APPLICATION NO. 03DRB-00145	PROJECT NO. 1002338	MH
PROJECT NAME N. ALB. Acres, UNIT B TRA. BL. 3		
EPC APPLICATION NO.		
APPLICANT / AGENT JOHN E MECHENBIER	PHONE NO. 828-1676	
ZONE ATLAS PAGE B-18		
<p>INT. RTNG.</p> <h2>ONE STOP COMMENT FORM LOG</h2>

**CITY OF ALBUQUERQUE
PLANNING DEPARTMENT
Development Review Board Comments**

Subject: North Albuquerque Acres, Unit B

DRB Application No.: 02-01905 (SBP)
Project Name: NORTH ALBU. ACRES, UNIT B
Agent: John Mechenbier

PROPOSED SITE DEVELOPMENT PLAN

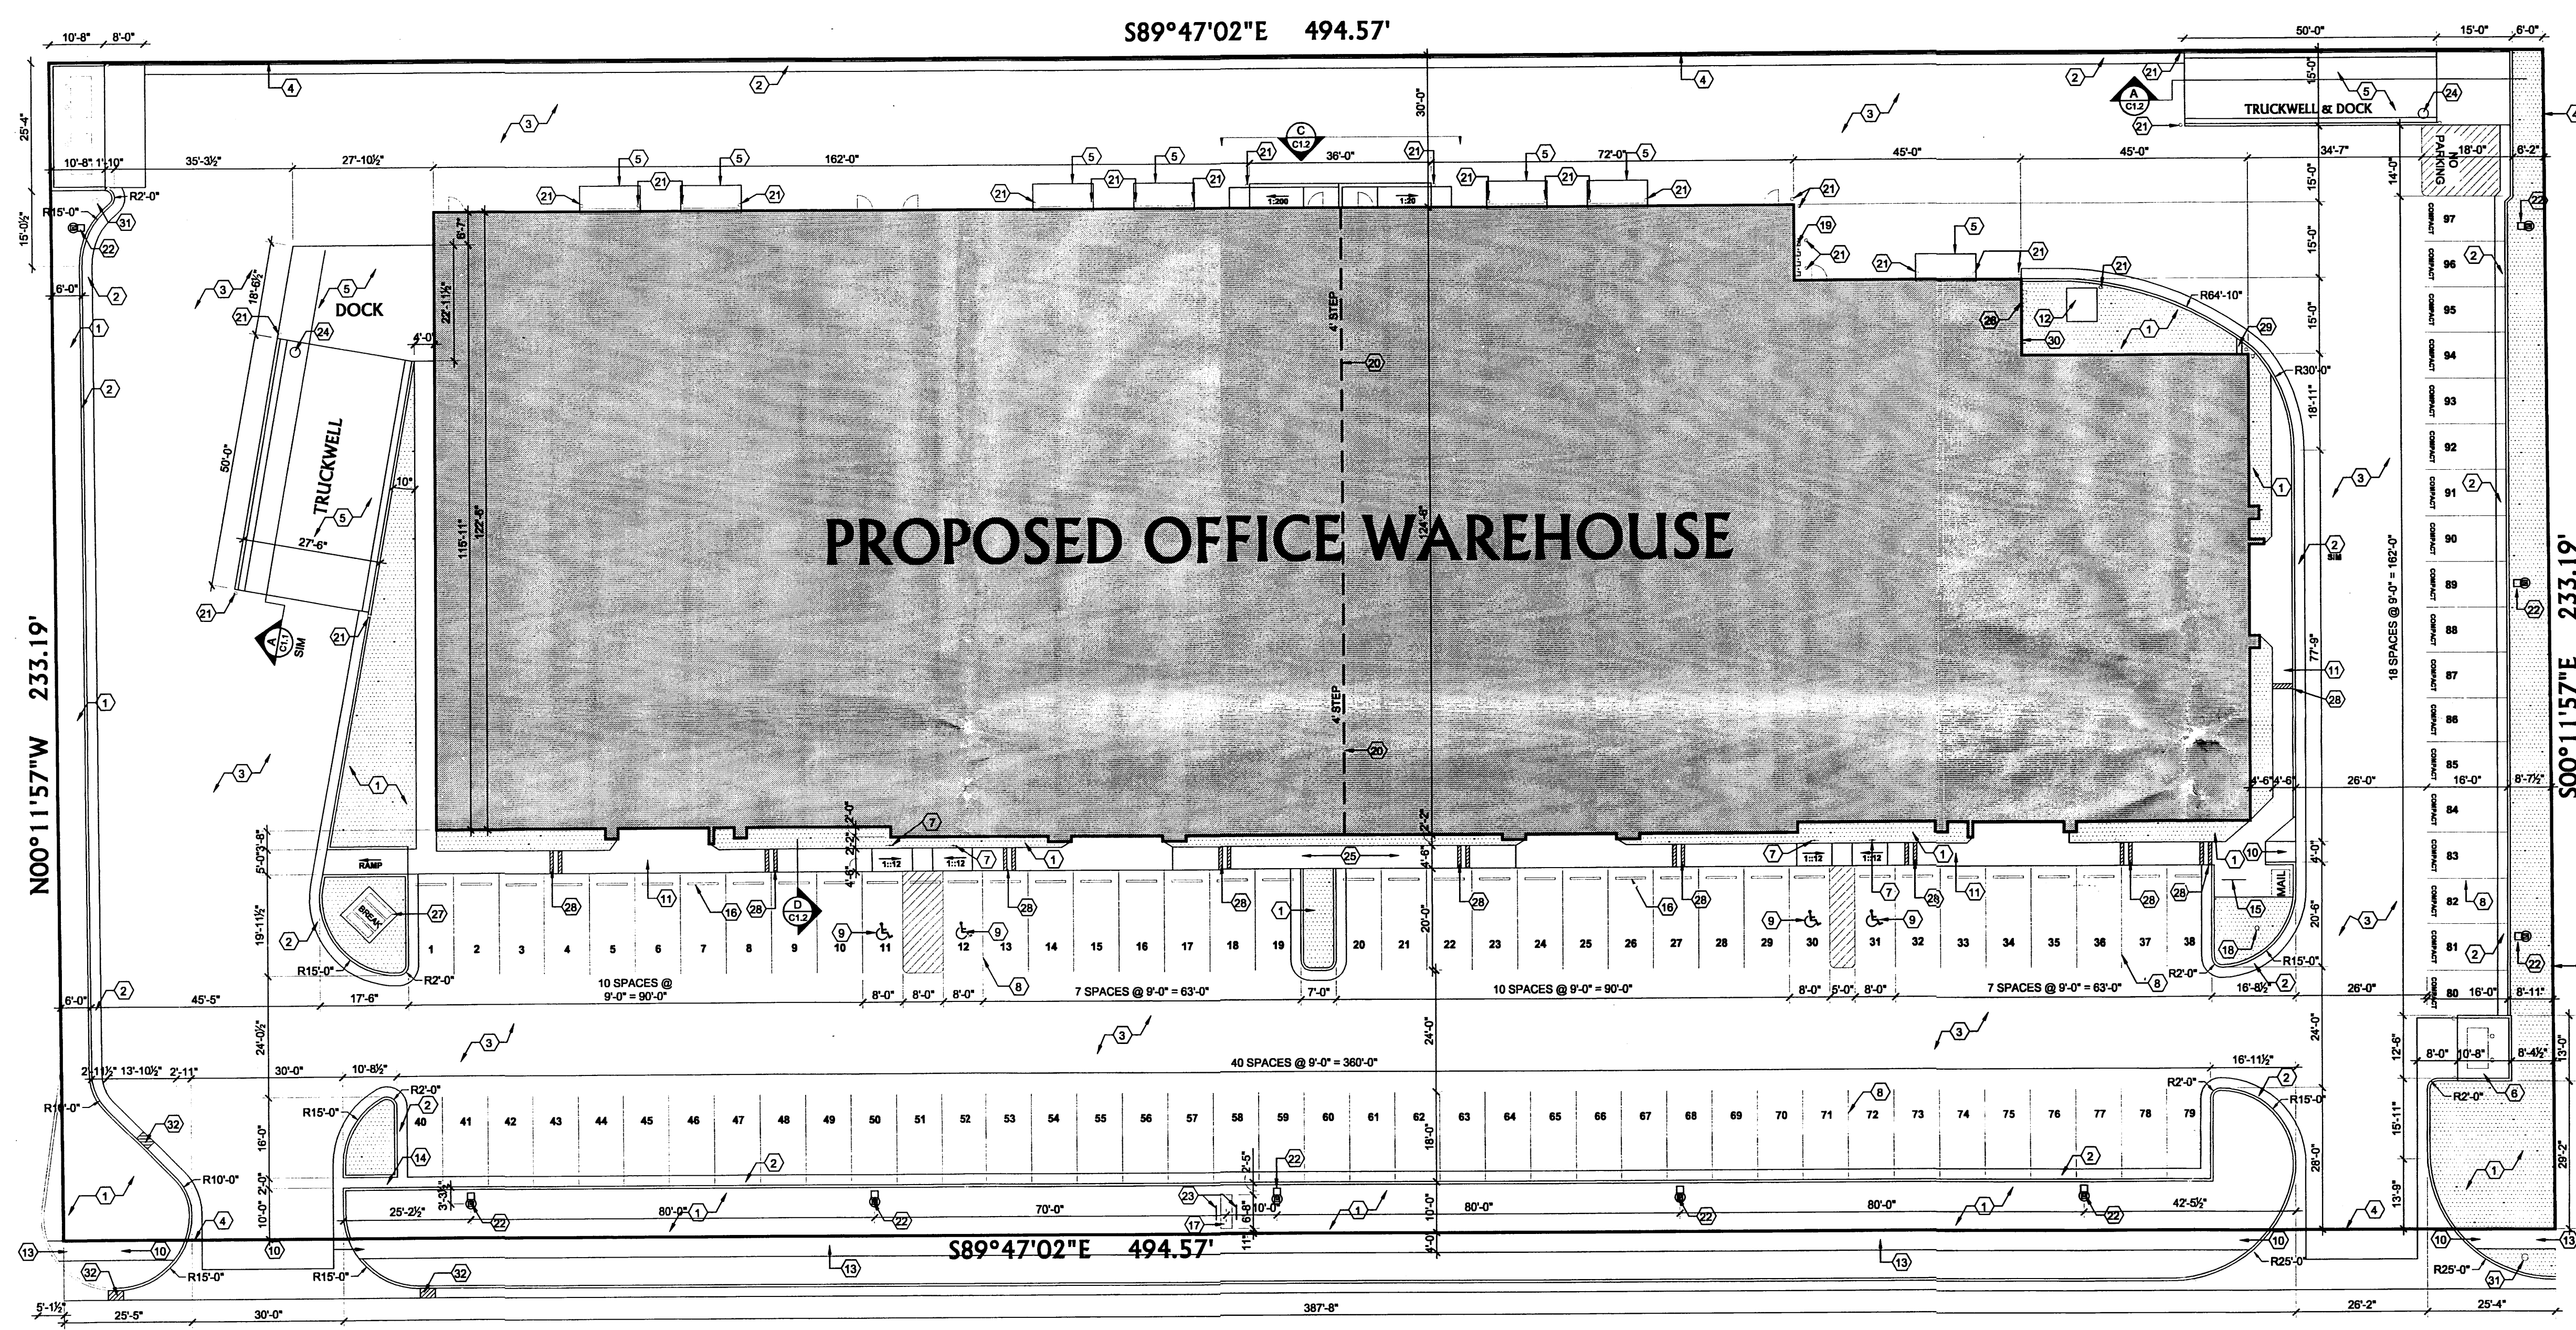
New Zoning Code regulations which were passed last October require an 8' wide sidewalk along the building. "Where building facades abut parking areas, pedestrian sidewalks no less than 8 feet in width, shall be provided adjacent to and along the full length of the building. A minimum width of six feet shall remain clear and unobstructed at all times for pedestrian use."

In addition, a pedestrian walkway is to be provided from all street sidewalks to the principal customer entrance(s) of the nearest buildings on site. "Pedestrian walkways within a site shall be a minimum of six feet in width, unobstructed, and clearly demarcated by the use of techniques such as special paving, grade separation or pavement marking of a permanent nature, except that clear width may be reduced to 4 feet 6 inches at tree wells for a maximum distance of ten feet."

No.	Comment
<input type="checkbox"/>	What is developed adjacent and across the street from this site?
<input type="checkbox"/>	How are the truck wells to be protected?
<input type="checkbox"/>	Correctly show all handicap ramps in public right-of-way.
<input type="checkbox"/>	How was the street improvements on the infrastructure list determined?

PLANT LEGEND

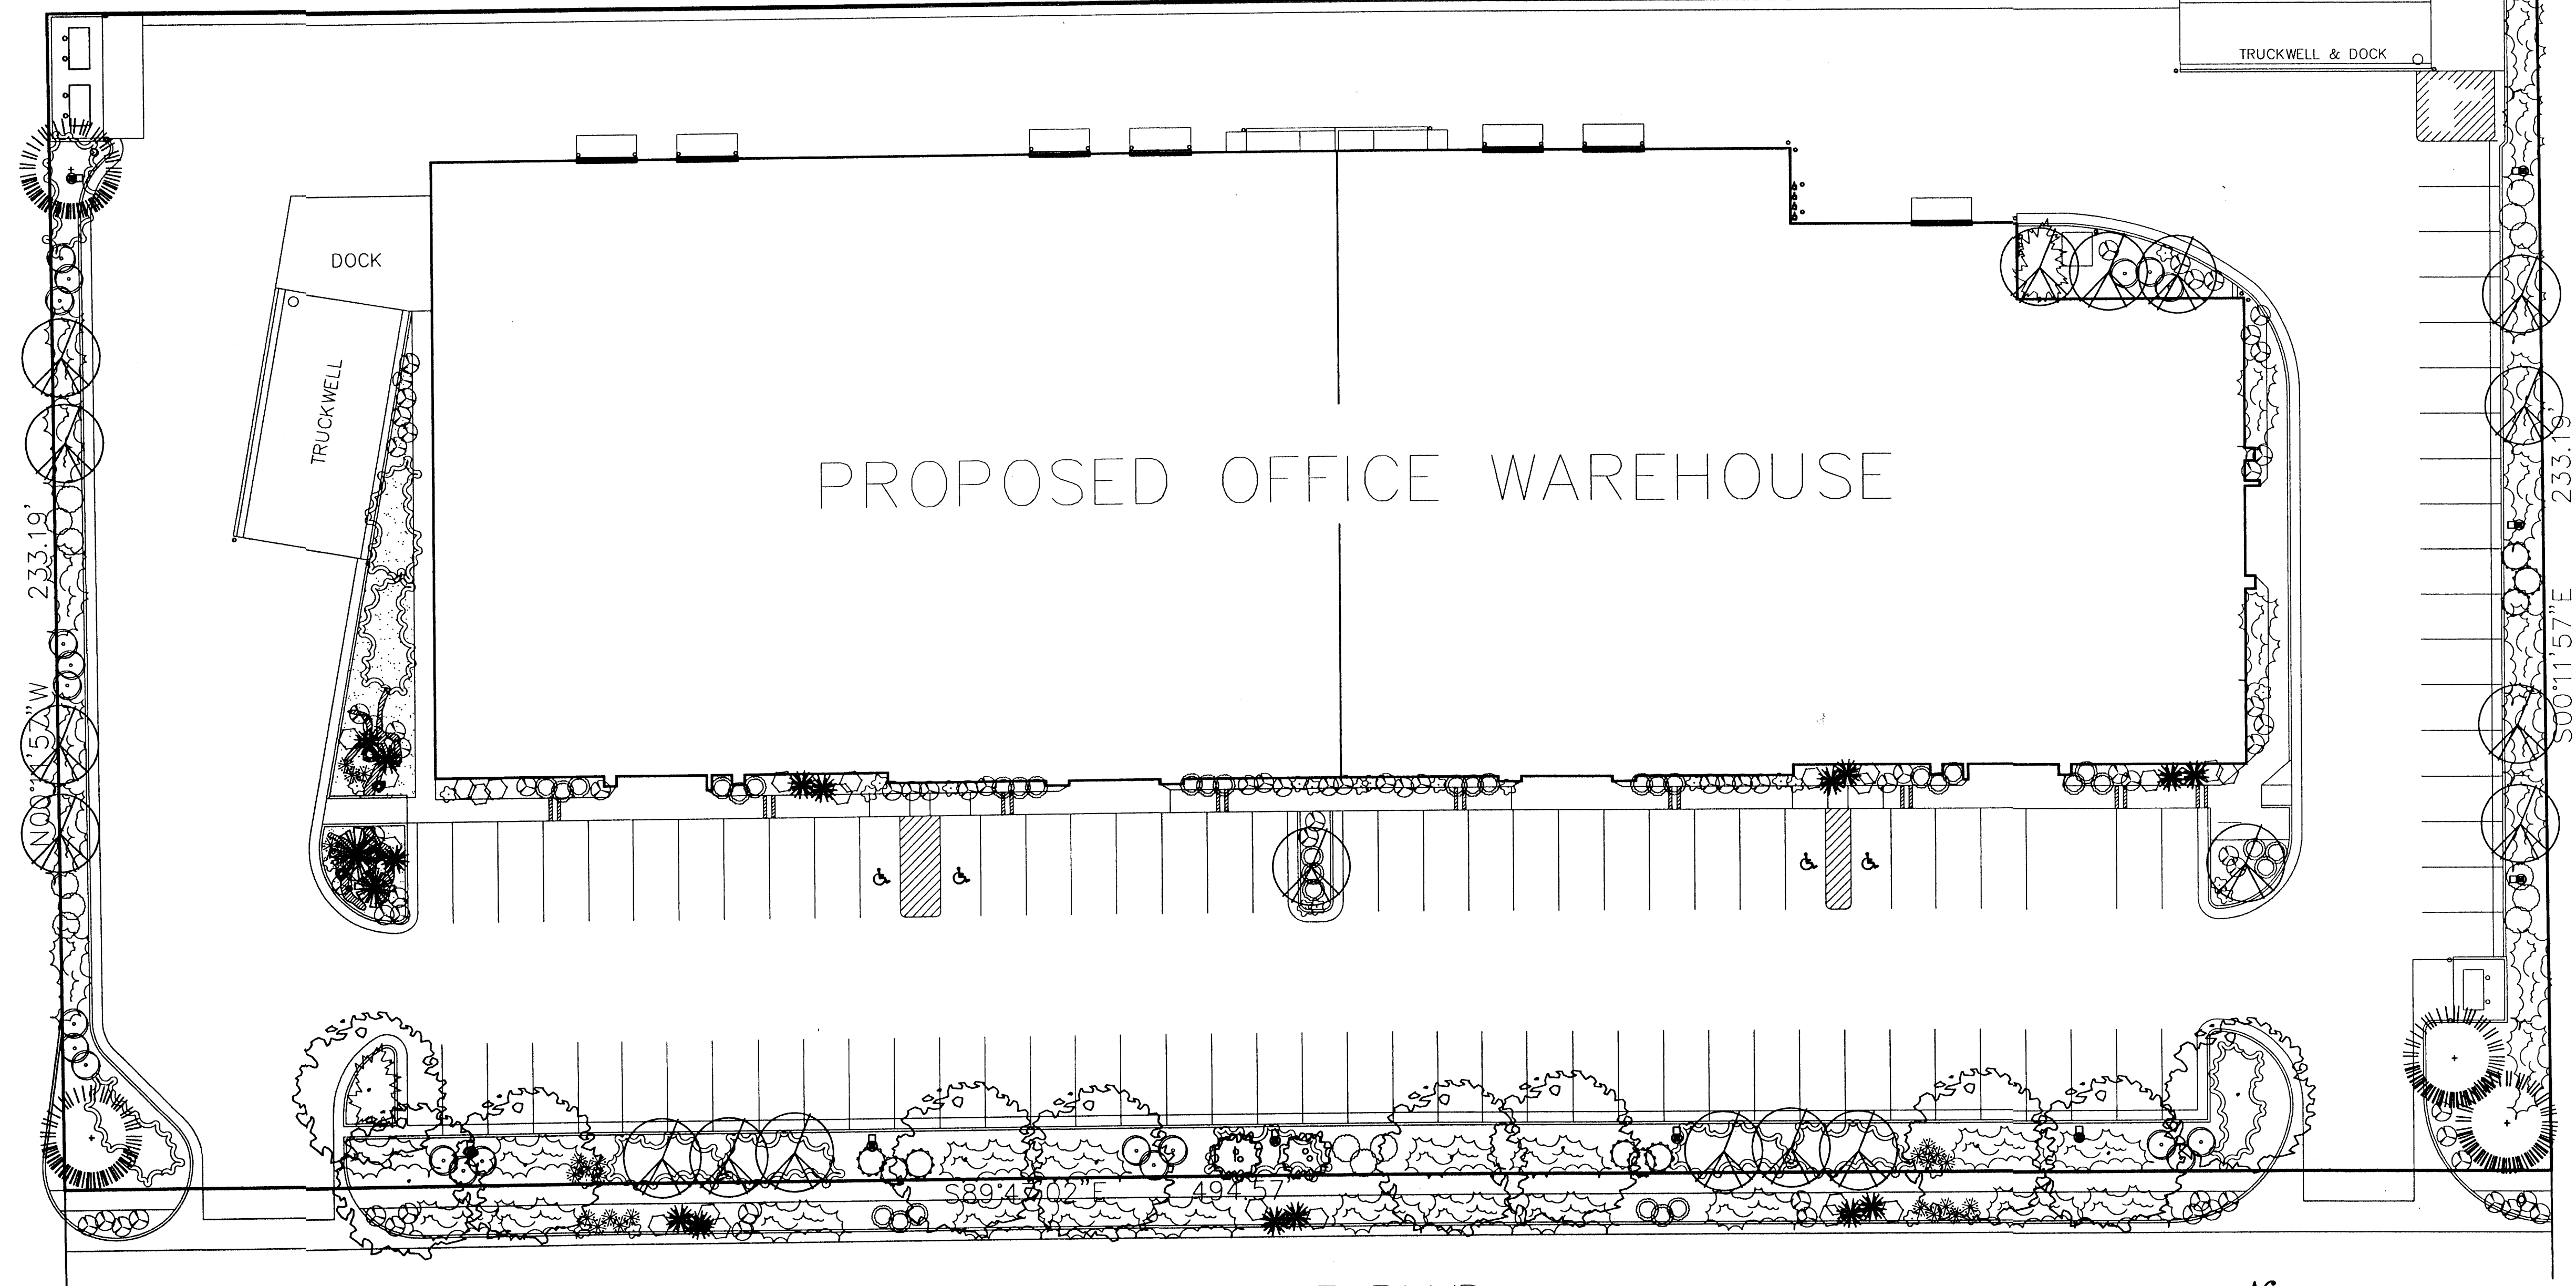
The 6' wide rear landscaping buffer is missing. Application documentation indicates a variance hearing scheduled with the ZHE later this month. Before Planning signs off on the site plan, we will need a copy of the ZHE decision, assuming he finds in your favor. If not, the site plan will need amending.

Finally, the Landscaping Plan includes 3 high water use trees. We strongly encourage the substitution of medium or low water use trees for the sake of responsible water conservation. Also, the junipers are strongly discouraged due to their high allergen characteristics.
